Application Ref:	3/2026/0629			 Ribble Valley Borough Council www.ribblevalley.gov.uk
Date Inspected:	26/8/26 & 21/9/26	Site Notice:	26/8/26	
Officer:	BT			
DELEGATED ITEM FILE REPORT:				
				REFUSAL

Development Description:	Regularisation of existing as-built clear glazing to the dormer and roof windows.
Site Address/Location:	29 Chatburn Park Drive, Clitheroe, BB7 2AY.

SHEET: AS-BUILT FLOOR PLANS
AND ELEVATIONS

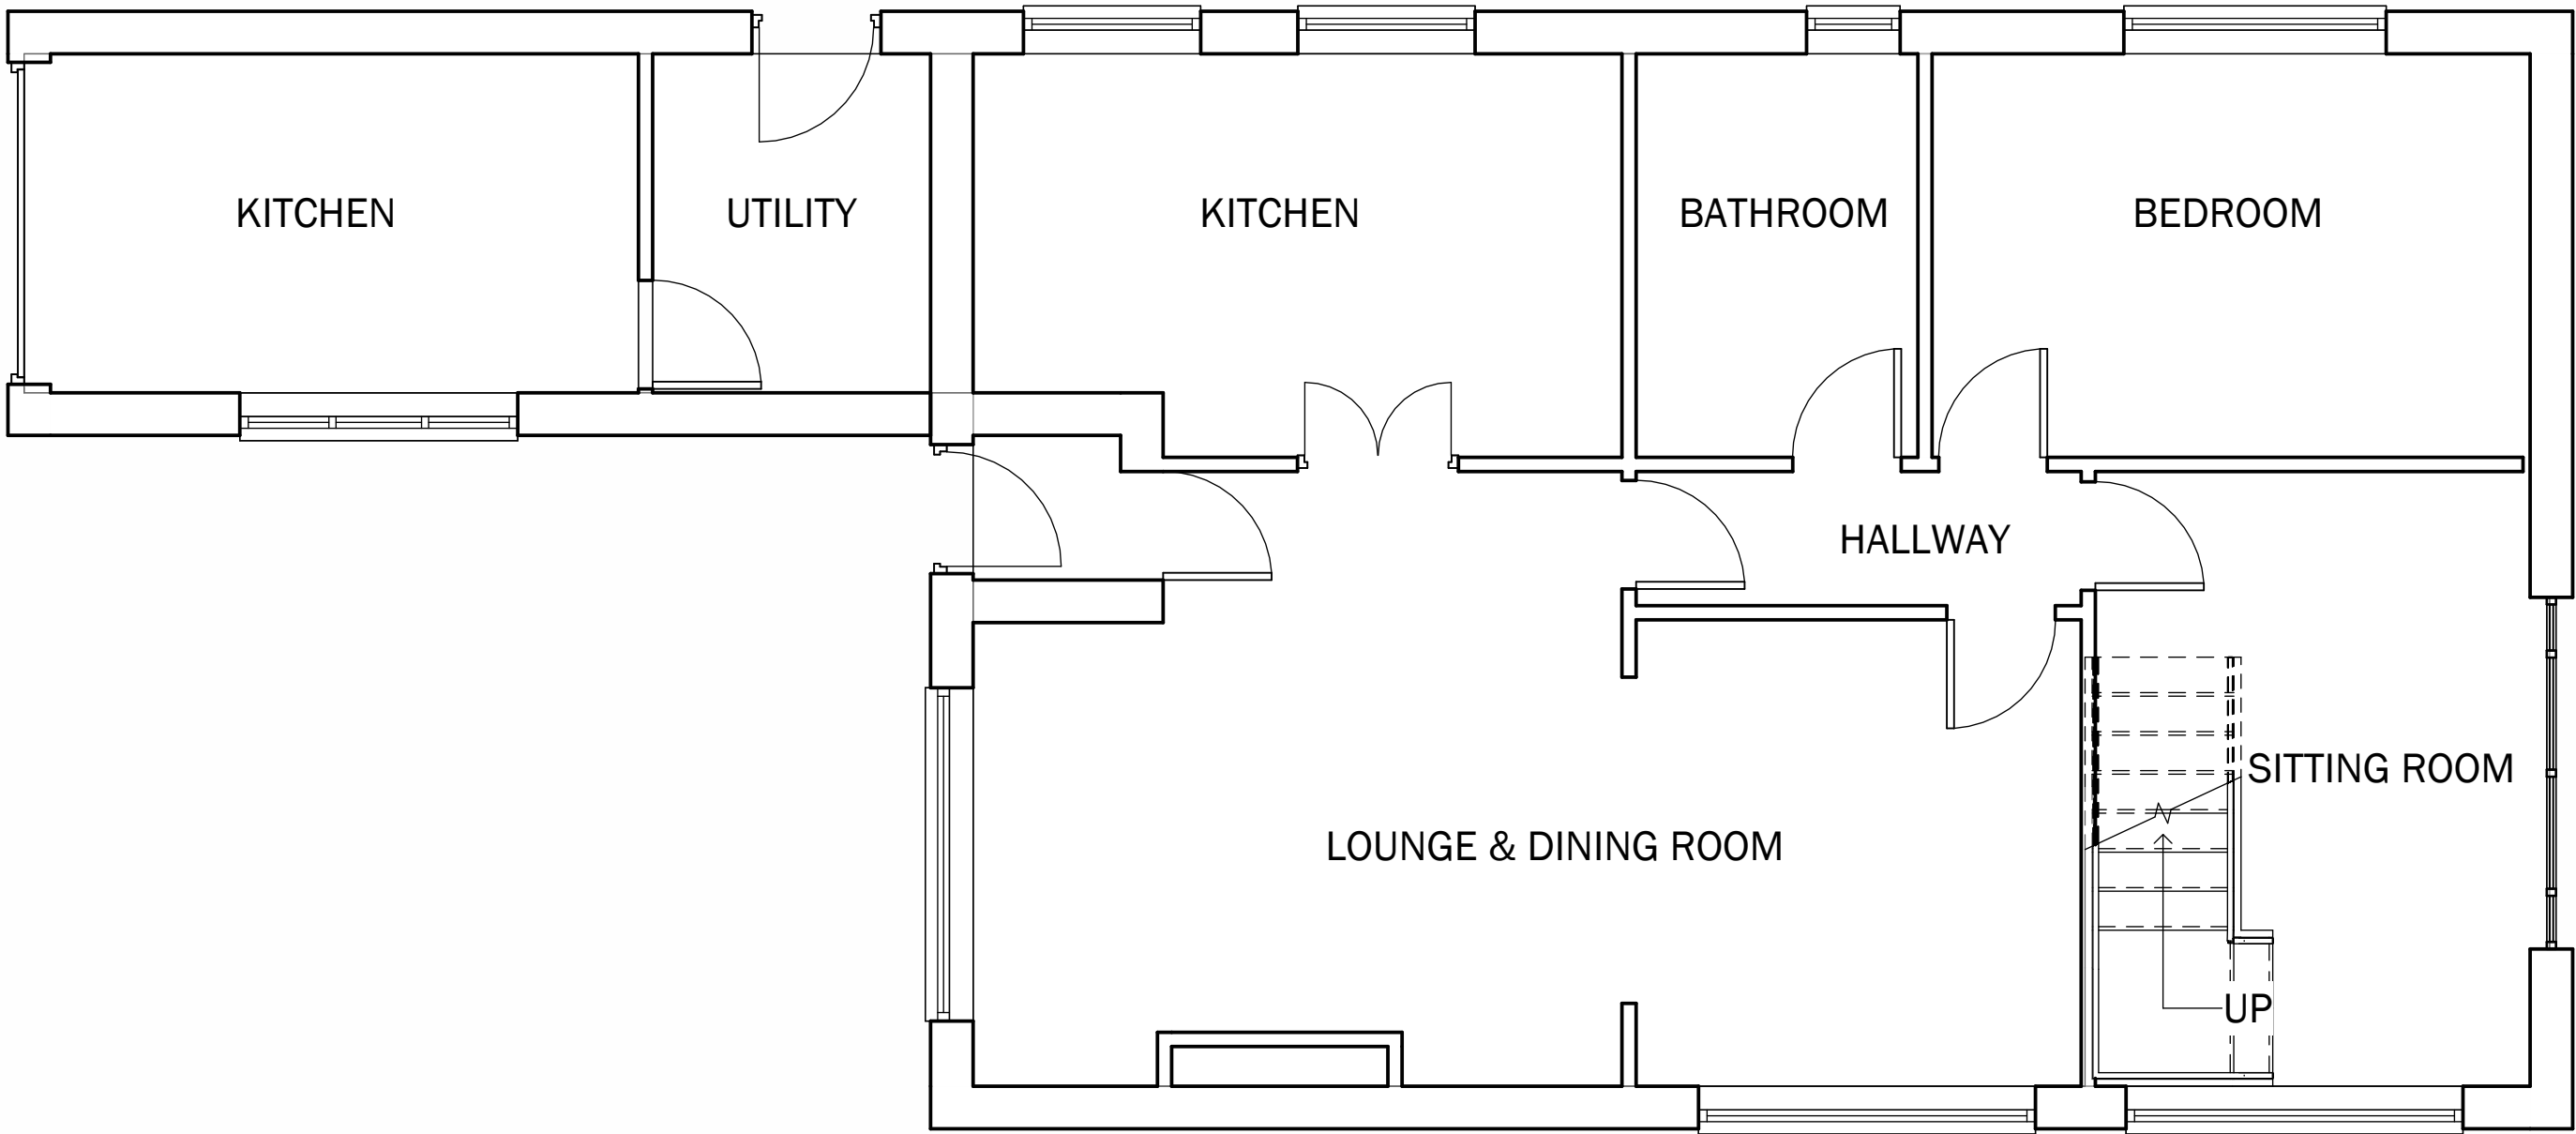
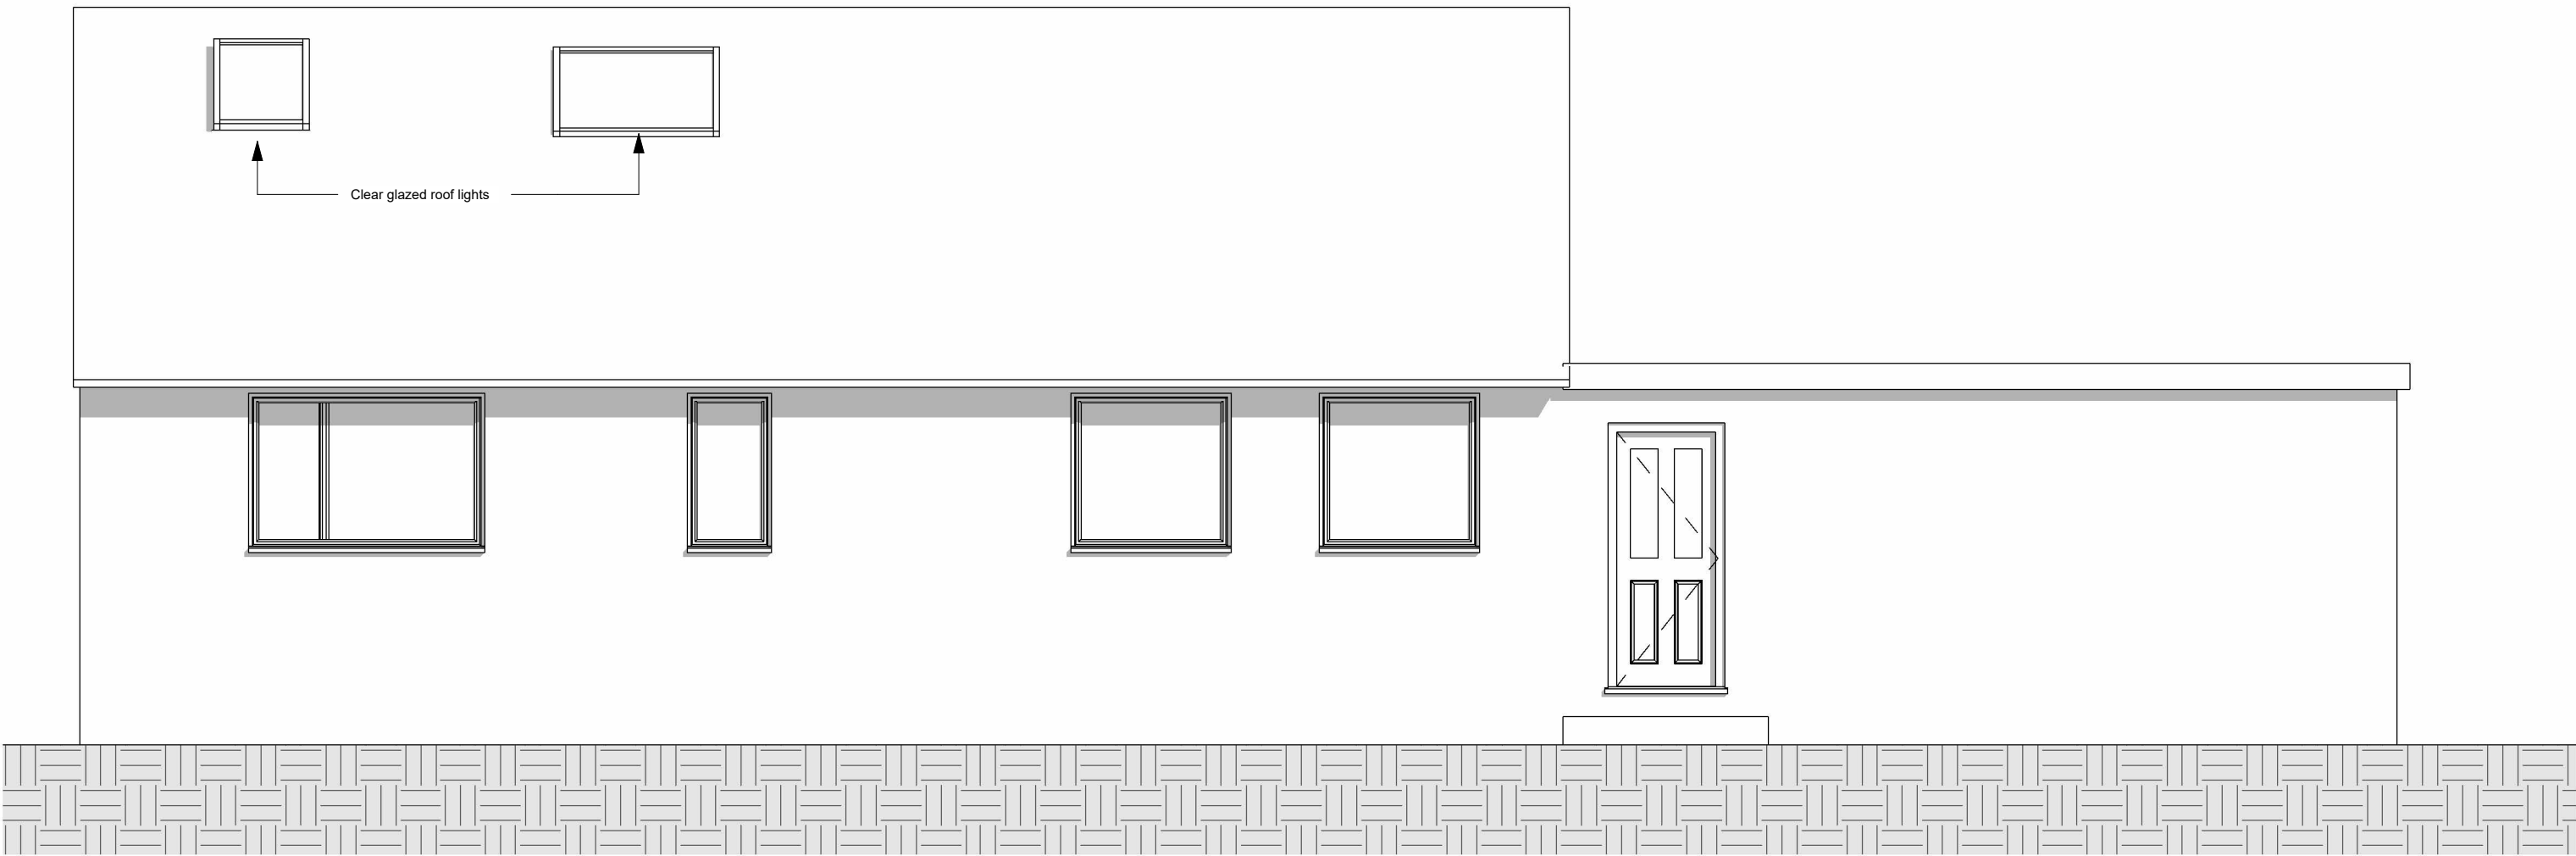
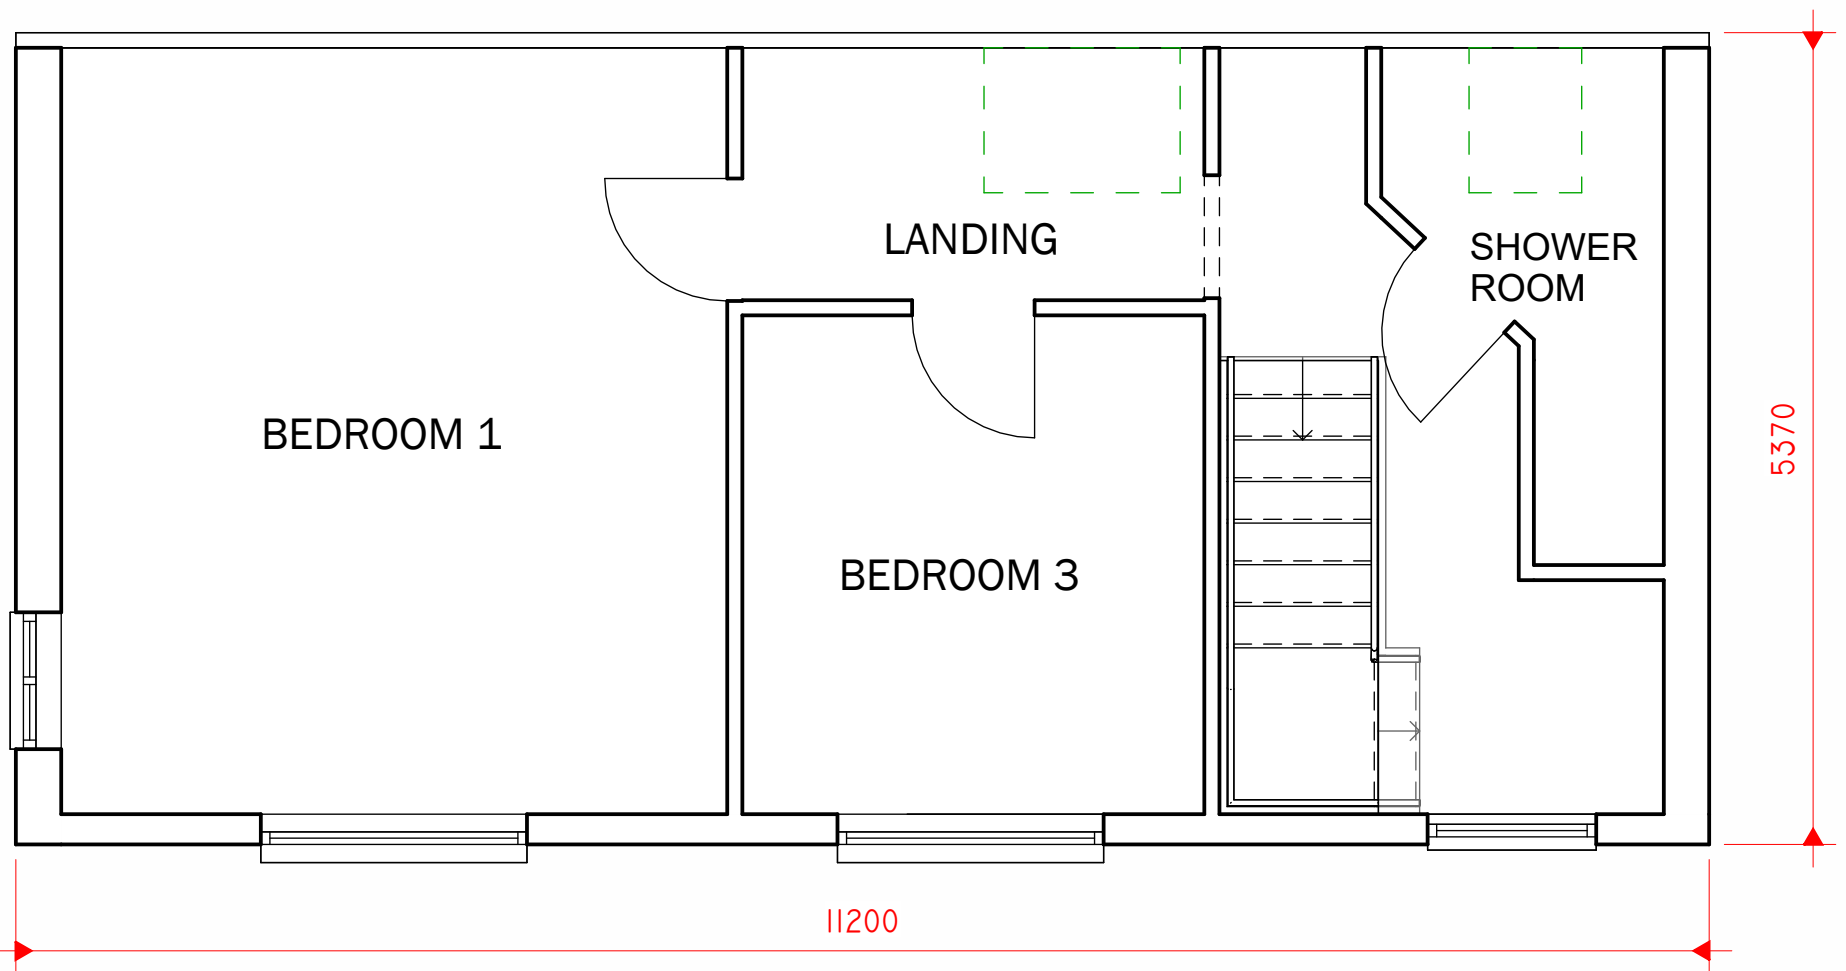
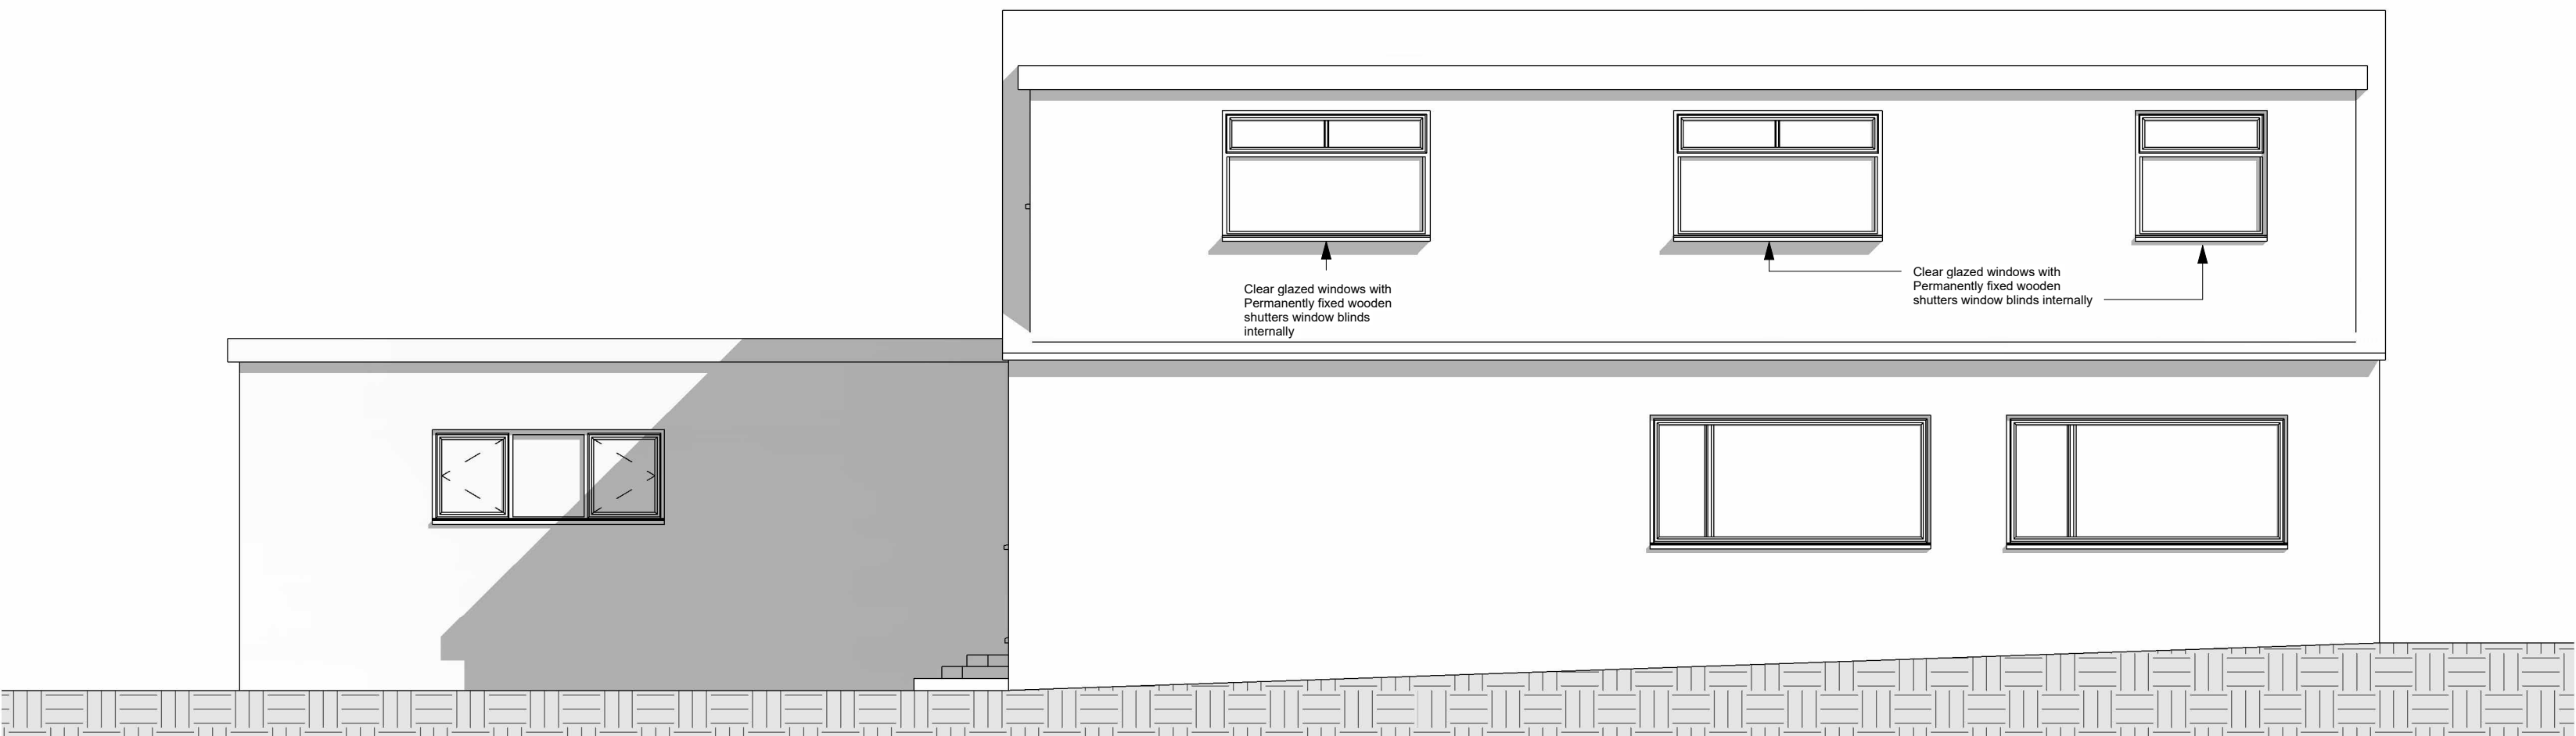
In this instance, officer site visit photo analysis from the interior of the application property and exterior of the rear garden area serving No. 31 Chatburn Park Drive shows that the unauthorised windows serving the landing and guest bedroom areas of the property's dormer extension provide unrestricted, elevated sideways views into the rear garden area of No. 31 Chatburn Park Drive and also towards the windows within the rear elevation of No. 31 Chatburn Park Drive. In addition, photographic analysis shows that the window serving the main bedroom area of the property's dormer extension provides unrestricted views towards the first floor windows within the side elevation of No. 31 Chatburn Park Drive. It is noted that the applicant has installed shutter blinds to each of the three windows within the dormer extension in an attempt to mitigate losses of privacy to the adjacent neighbouring property however photographic analysis shows the aforementioned occurrences of overlooking as still being prevalent with the blinds in place. As such, it is considered that retention of the unauthorised windows would result in an unacceptable loss of privacy to the neighbouring residents of No. 31 Chatburn Park Drive.

In addition, whilst officer site visit photo analysis from the interior of the application property does not show clear lines of sight towards the first floor window opening within South-western gable end of No. 27 Chatburn Park Road or its rear garden area, it is considered that the unauthorised rooflights could provide opportunities for overlooking towards the aforementioned bedroom window and rear garden area, particularly from the perspective of taller occupants. Furthermore, officer site visit photo analysis from the interior of the aforementioned first floor bedroom window within No. 27 Chatburn Park Drive show clear intervisibility between the bedroom window opening and unauthorised rooflights with the interior of the application property's landing and shower room areas also being partly visible which in turn creates the perception of being overlooked. As such, it is considered that retention of the unauthorised rooflights would result in an unacceptable loss of privacy to the neighbouring residents of No. 27 Chatburn Park Drive.

Taking account of the above, it is considered that retention of the unauthorised windows and rooflights, by virtue of their height, orientation and proximity to the neighbouring properties of No. 27 Chatburn Park Drive and No. 31 Chatburn Park Drive would be unduly harmful to the amenity of the occupants of these properties due to the resultant loss of privacy that would occur. The proposed development would therefore fail to satisfy the requirements of Policy DMG1.

01:	Retention of the unauthorised windows and rooflights, by virtue of their height, orientation and proximity to the neighbouring properties of No. 27 Chatburn Park Drive and No. 31 Chatburn Park Drive would be unduly harmful to the amenity of the occupants of these properties due to the resultant loss of privacy that would occur. The proposed development would therefore fail to satisfy the requirements of Policy DMG1.
------------	---
